Application No: A/24/21/PL
Site Address: Land South of Water Lane Angmering
Description of works: Erection of a temporary sales cabin with 4 parking spaces and associated landscaping. CIL Zone 1 - This application is zero rated as temporary building.

Thank you for your internet representation made on 16th March 2021 which has been recorded as an objection with the comments as follows:

Project  
**Land at Water Lane,  
Angmering, West Sussex.**  
Drawing Title  
**Sales Area Layout**

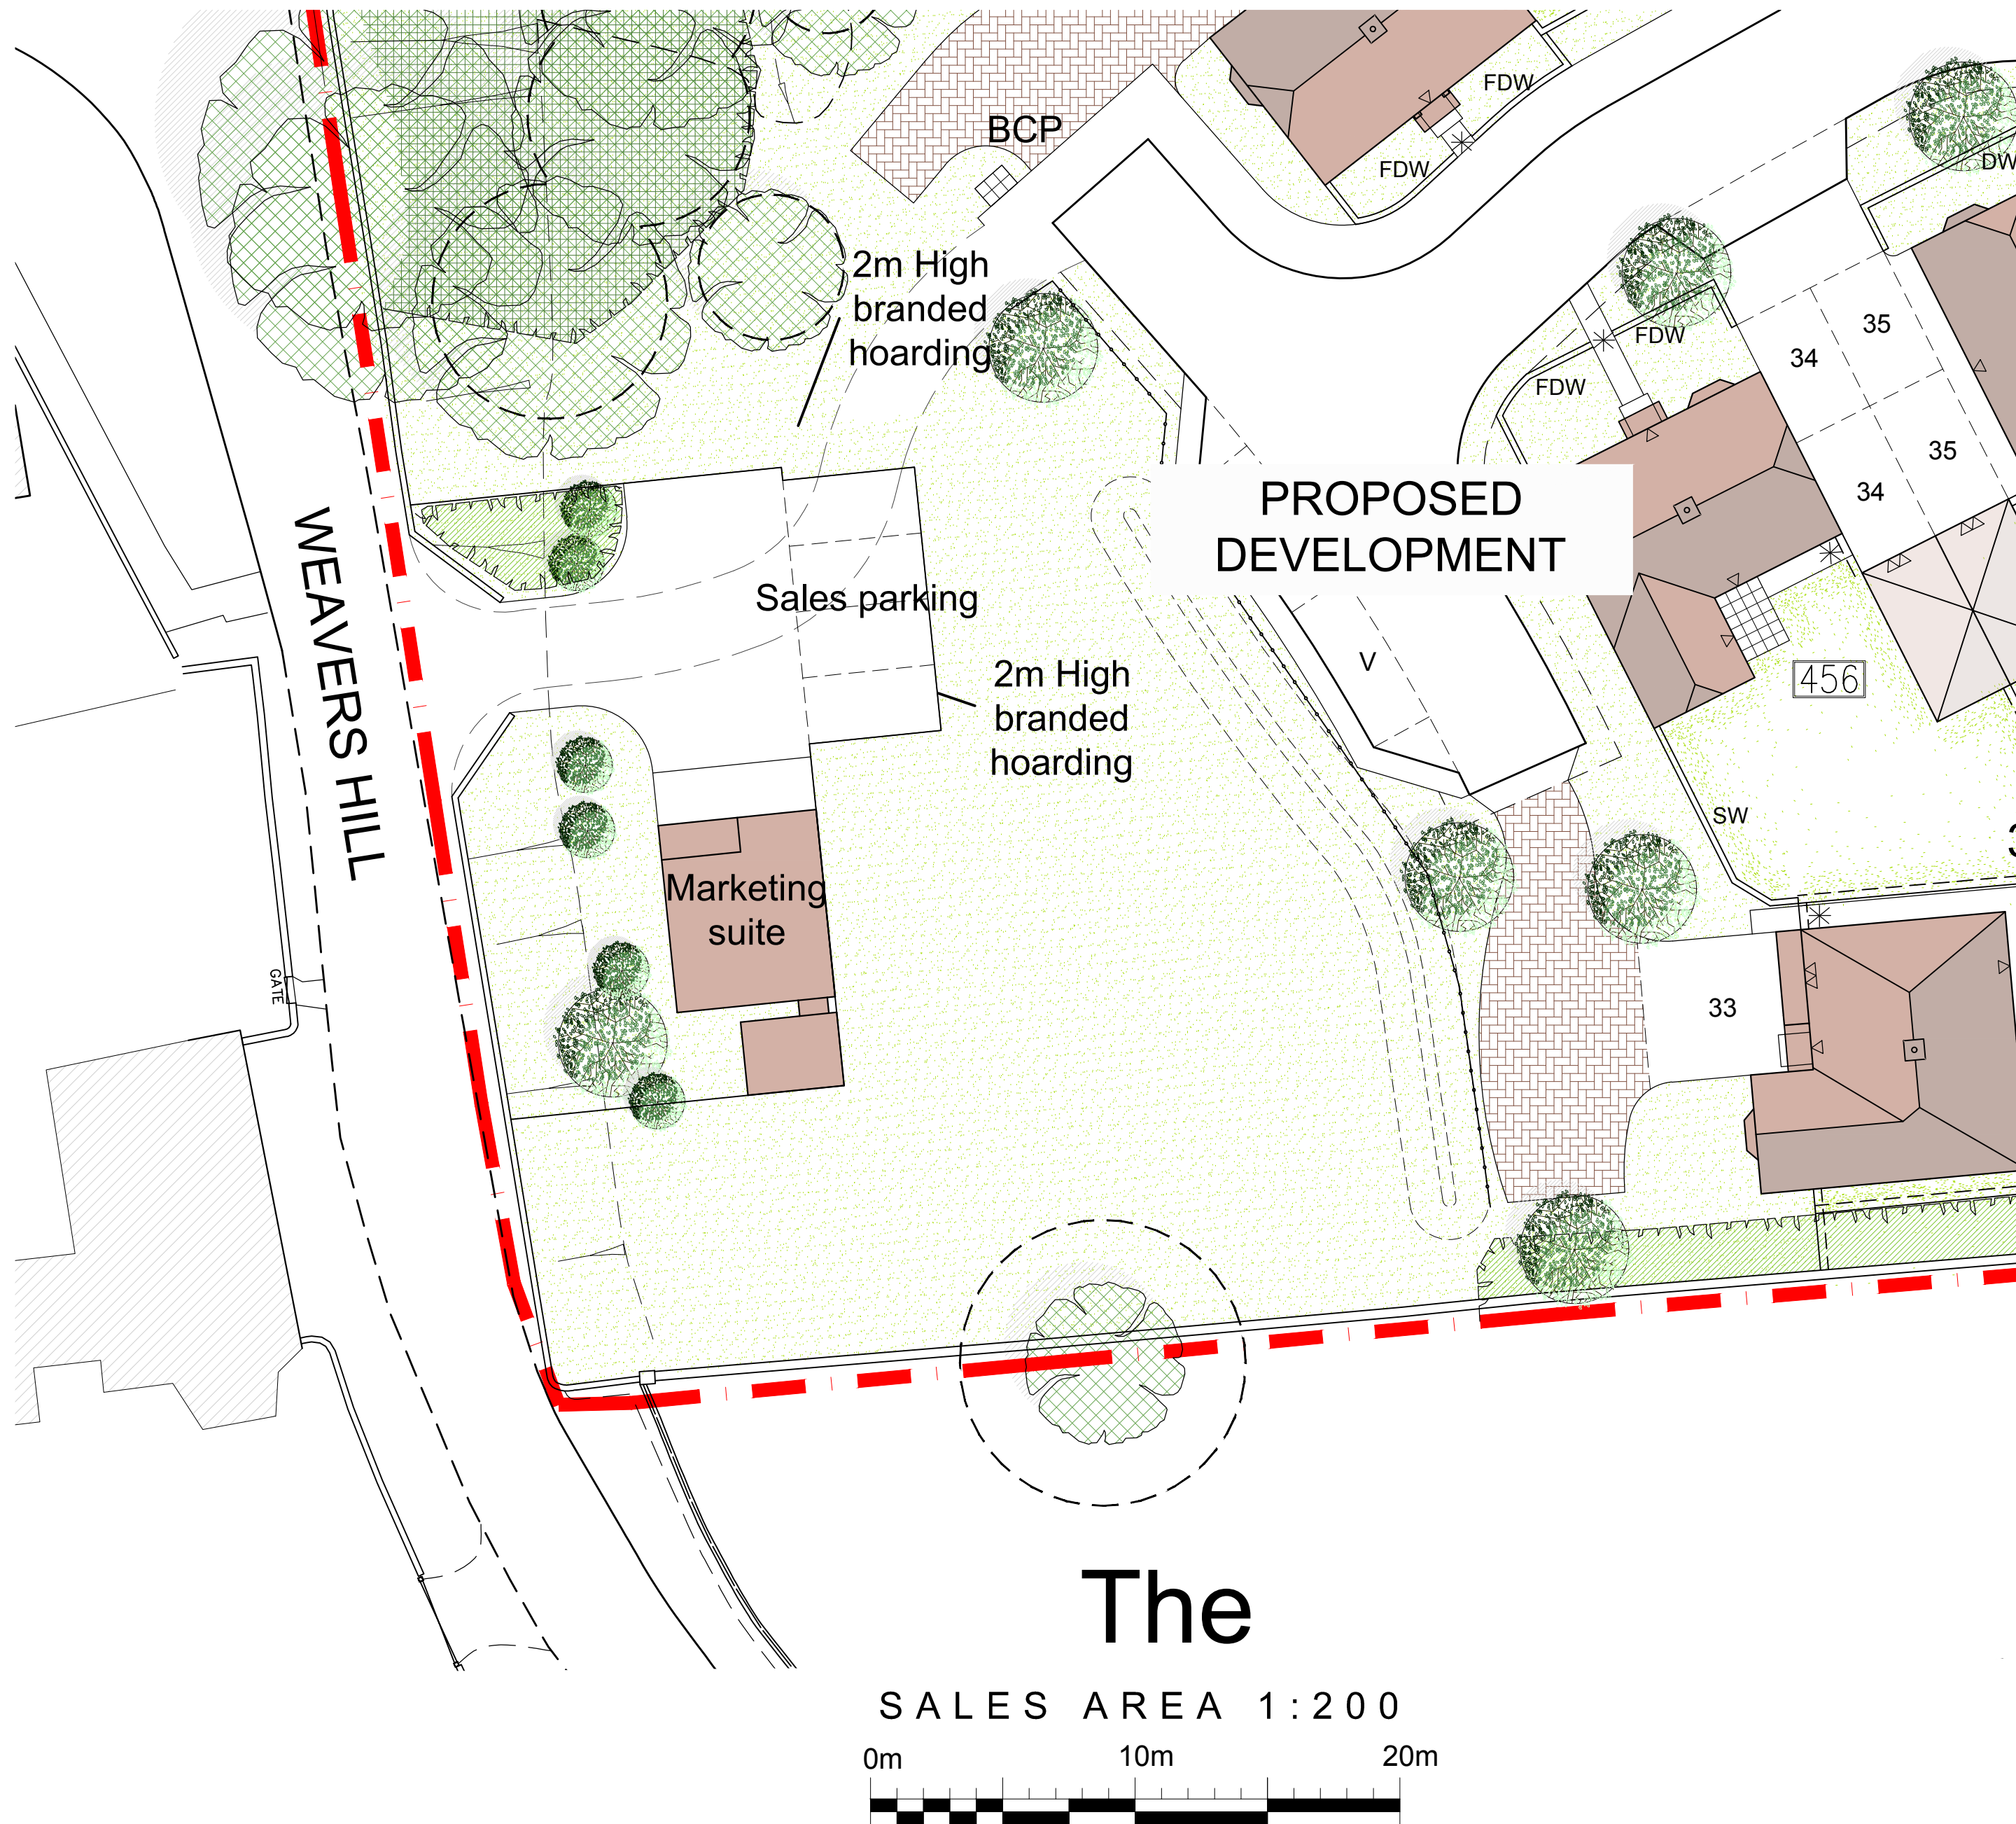
The section of flint wall which is going to be demolished for the entrance to the sales cabin is within the Angmering Conservation Area (as shown on Arun District Council plan dated 2014) and is of historic interest, worth preserving and, a modern sales cabin which is designed to attract attention for a commercial purpose, will have a negative and adverse impact to this area. The plan will have a detrimental effect on the character of the conservation area with two Grade II properties, one opposite the site and one adjacent to the site. The sales cabin is to market a residential development consisting of at least 150 properties, a multiple year project, so although the plan states the sales cabin will be a temporary arrangement, it does not give a specific time scale and is highly likely that the sales cabin will be in place for multiple years.

The entrance of the proposed sales area has been placed on the brow of Weavers Hill, a narrow lane that has multiple blind spots. The scale of the development will attract constant incremental traffic for multiple years, entering and exiting the sales cabin site on a pinch point of Weavers Hill, close to a blind spot on the lane. Weavers Hill is used by pedestrians, both residents and leisure walkers enjoying the character of the conservation area, there is no pedestrian pavement in the area that the sales cabin is proposed to be located and walkers use the lane with motor vehicles. Clearly this sales cabin will adversely compromise the highway safety for pedestrians and other road users for multiple years.

DWH Static Banner Flag Sign
Wood effect Square Aluminium Post
6000mm x 150mm x 150mm

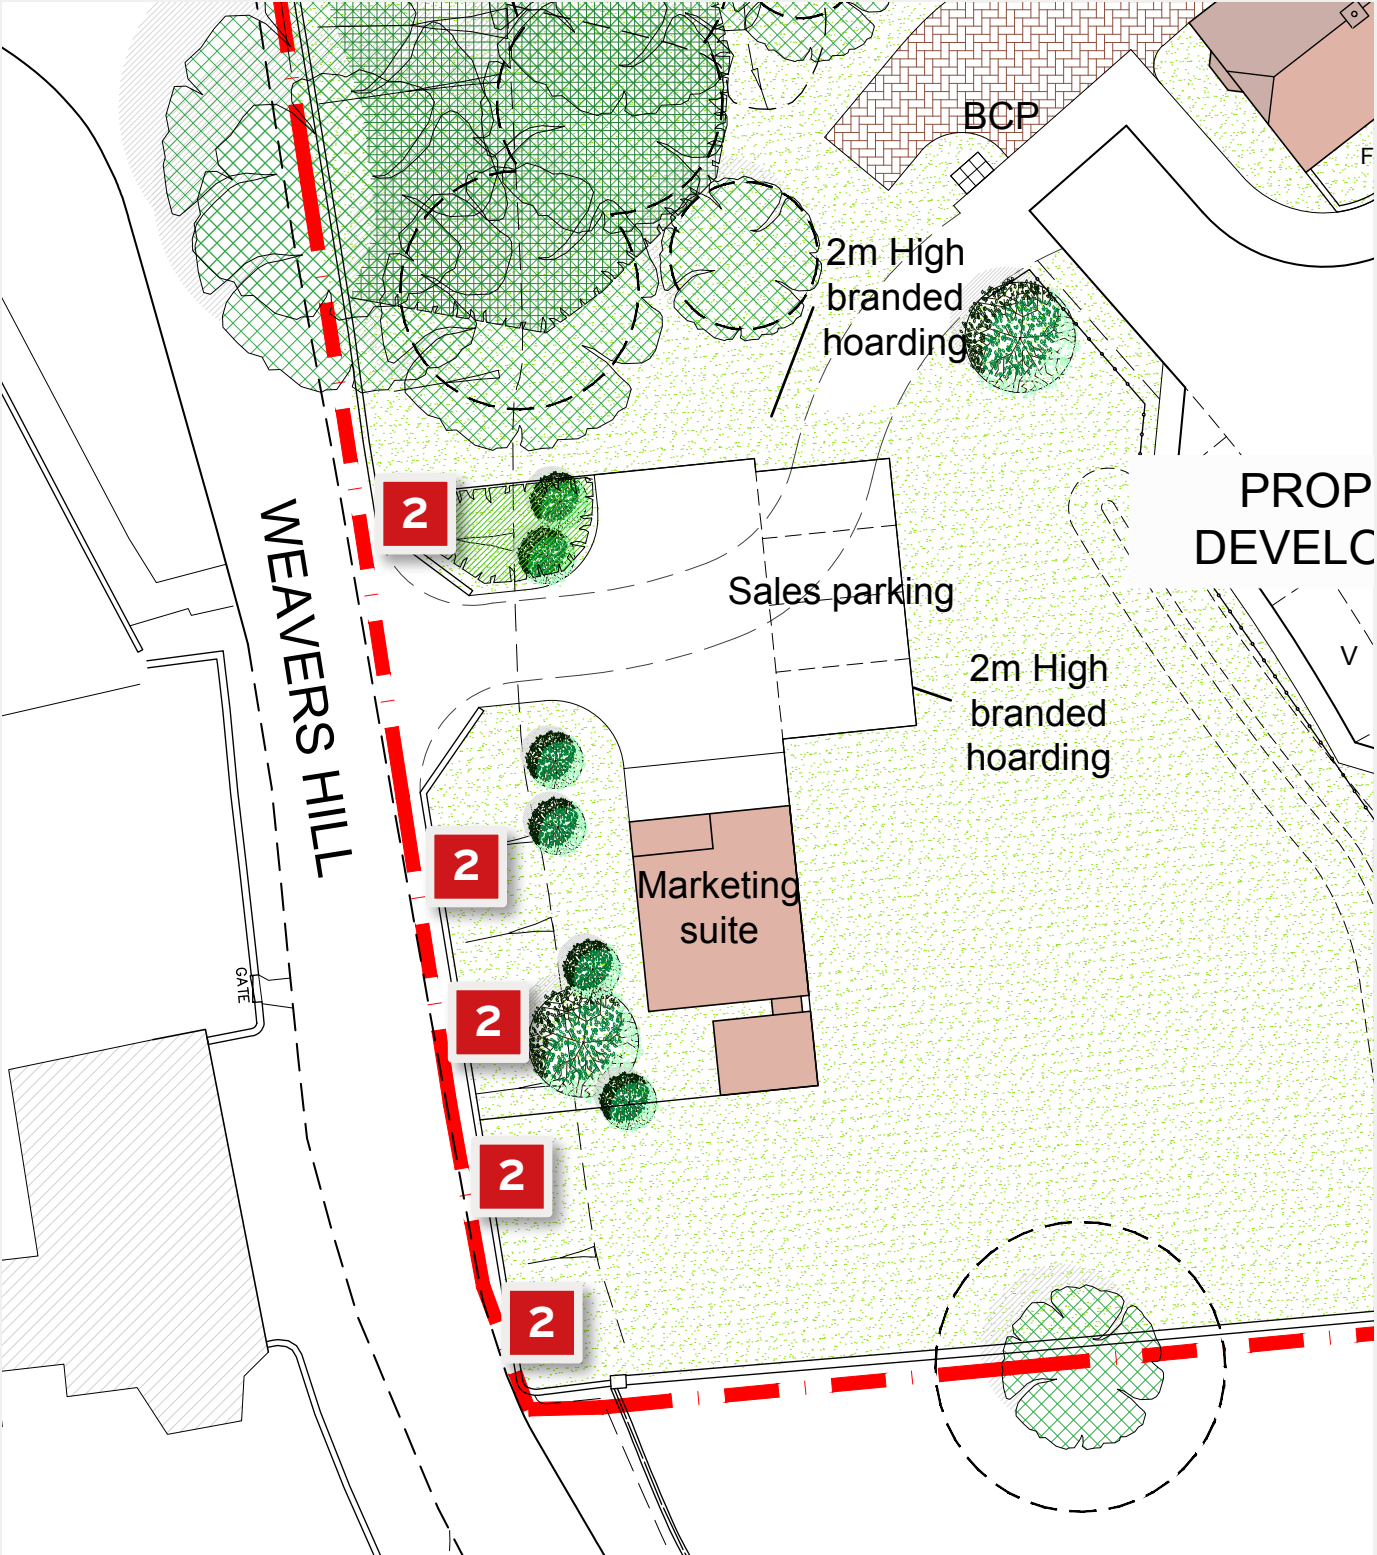
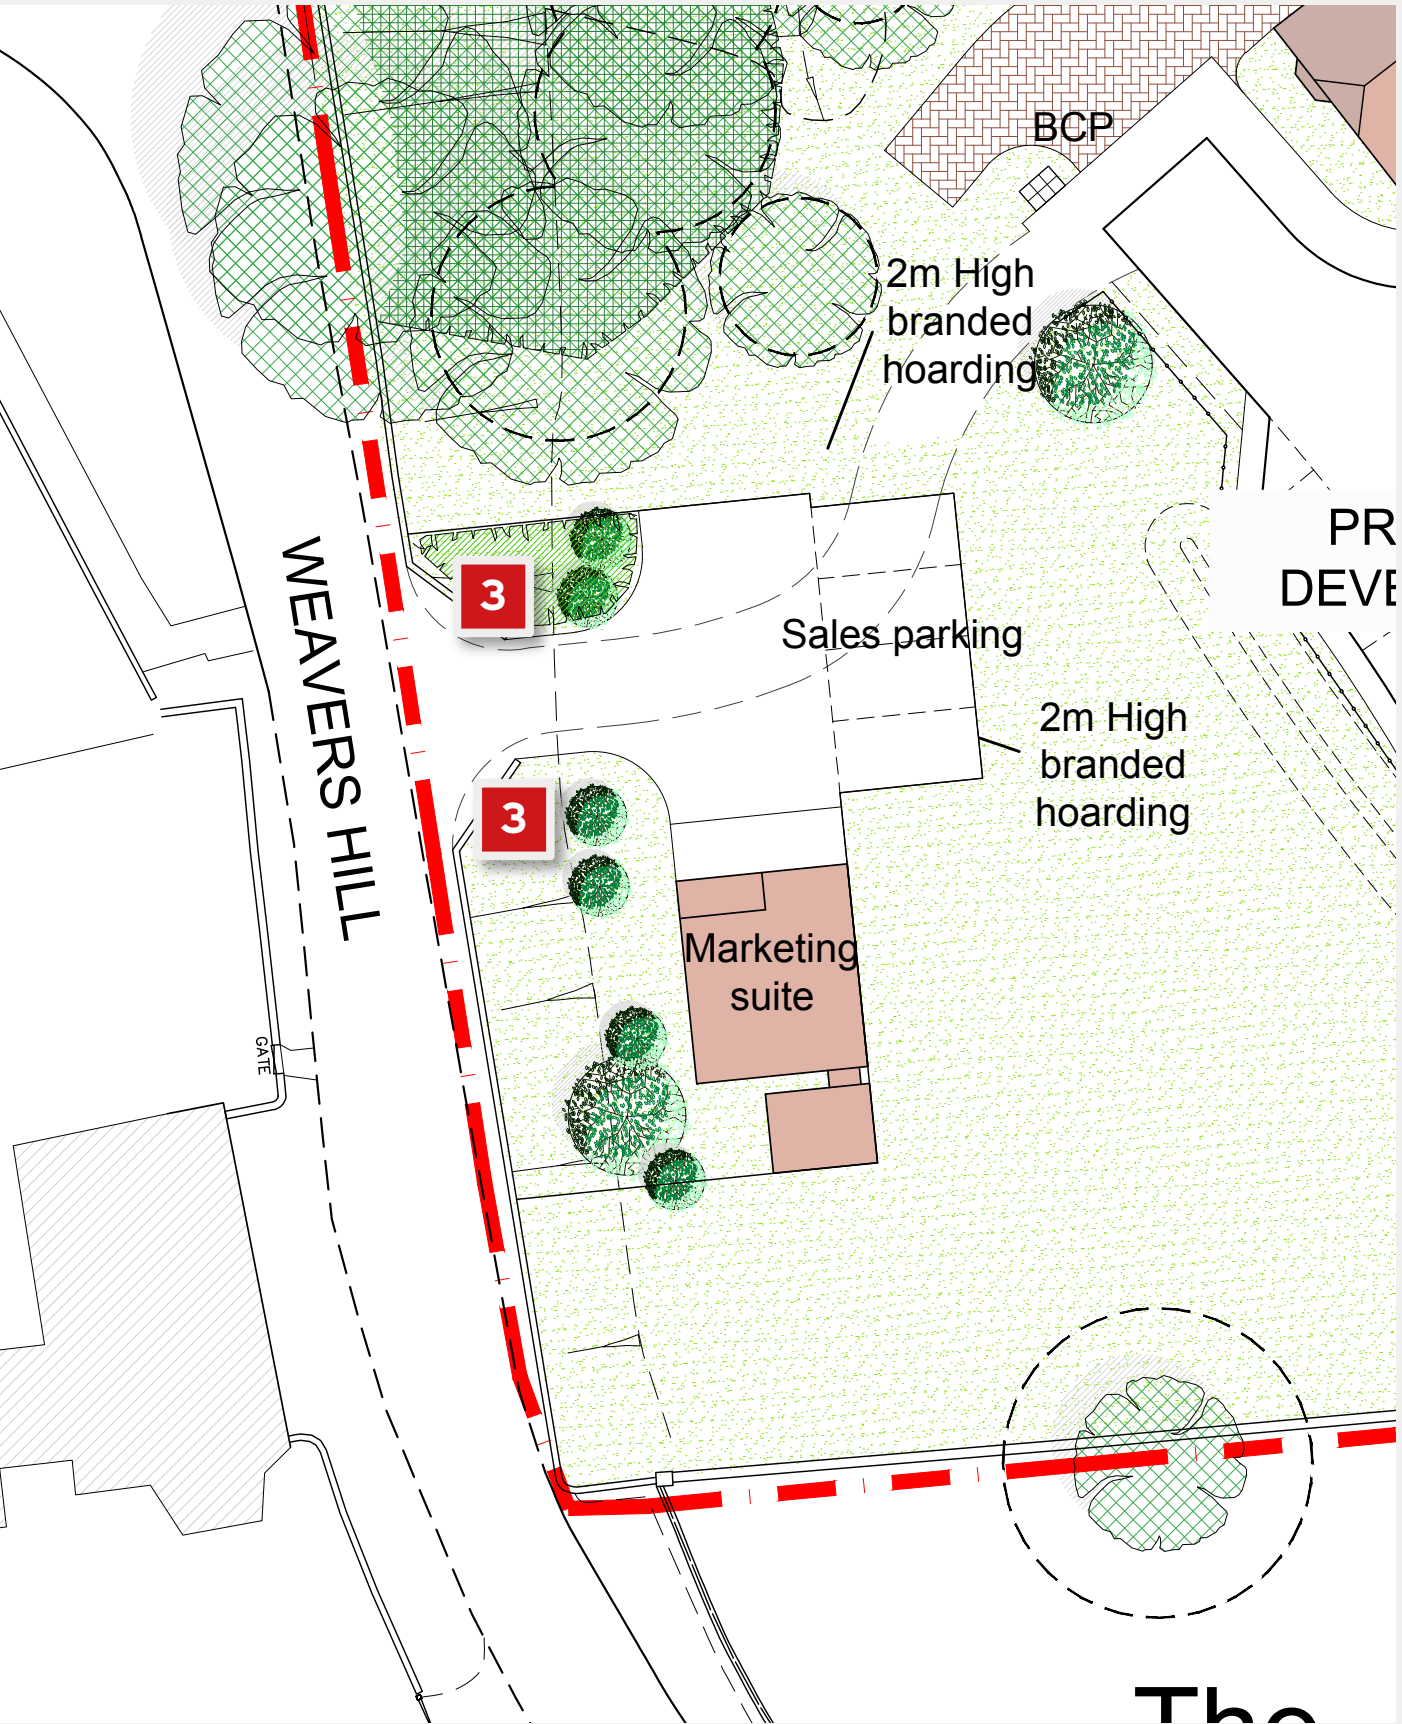
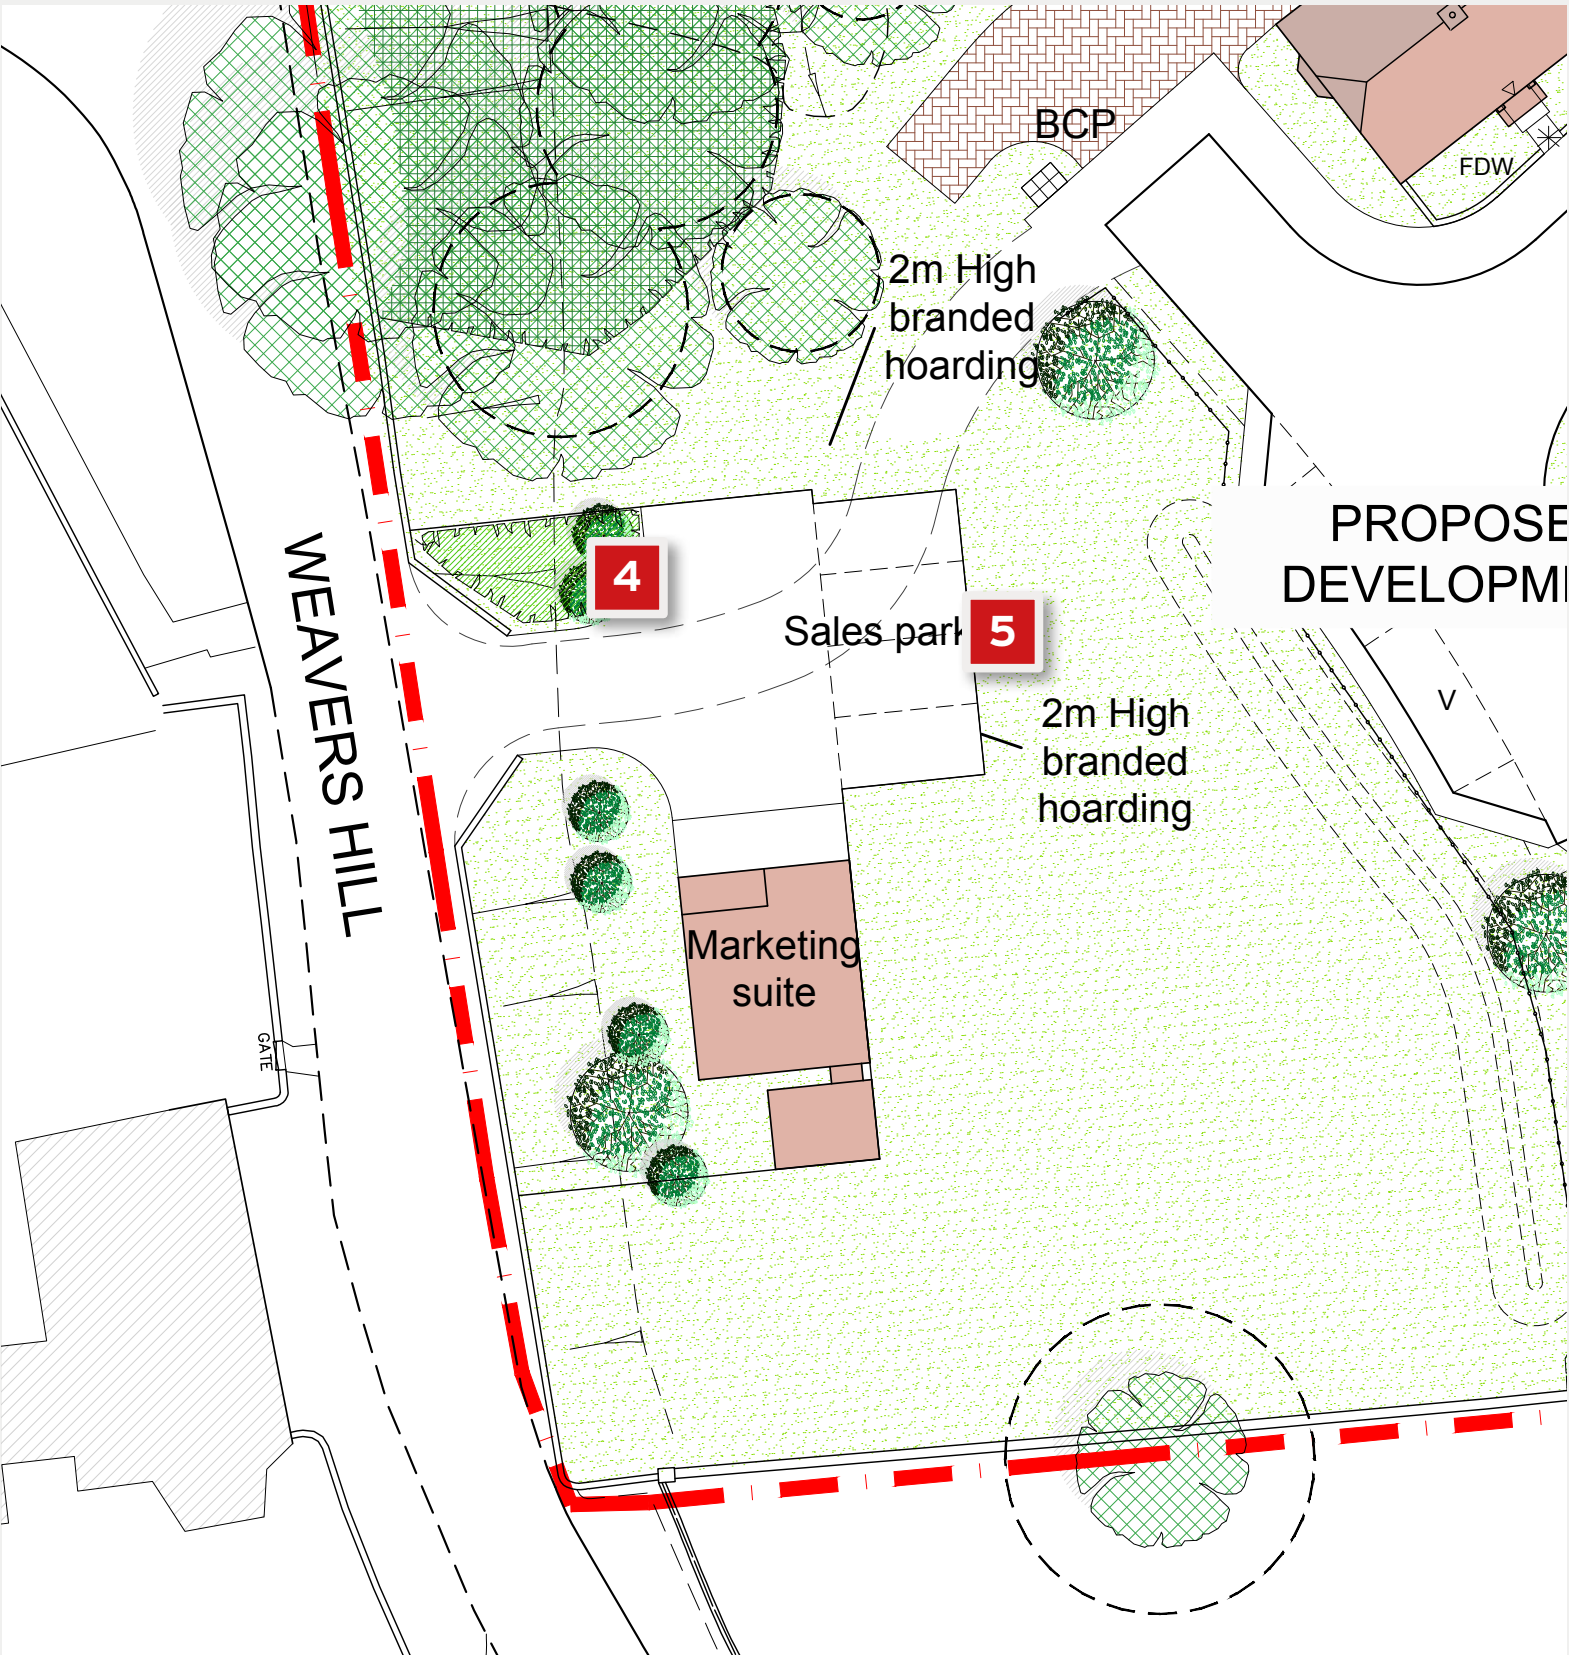
The erection of 10 advertising totem signs and 5 advertising flags, prominent commercial structures designed

to attract attention from a distance, will be totally out of place and will have a detrimental effect for multiple years on the character of the Angmering Conservation Area. The flags and the associated rope will generate noise in the wind and cause disturbance to the residential properties close to the site for multiple years.
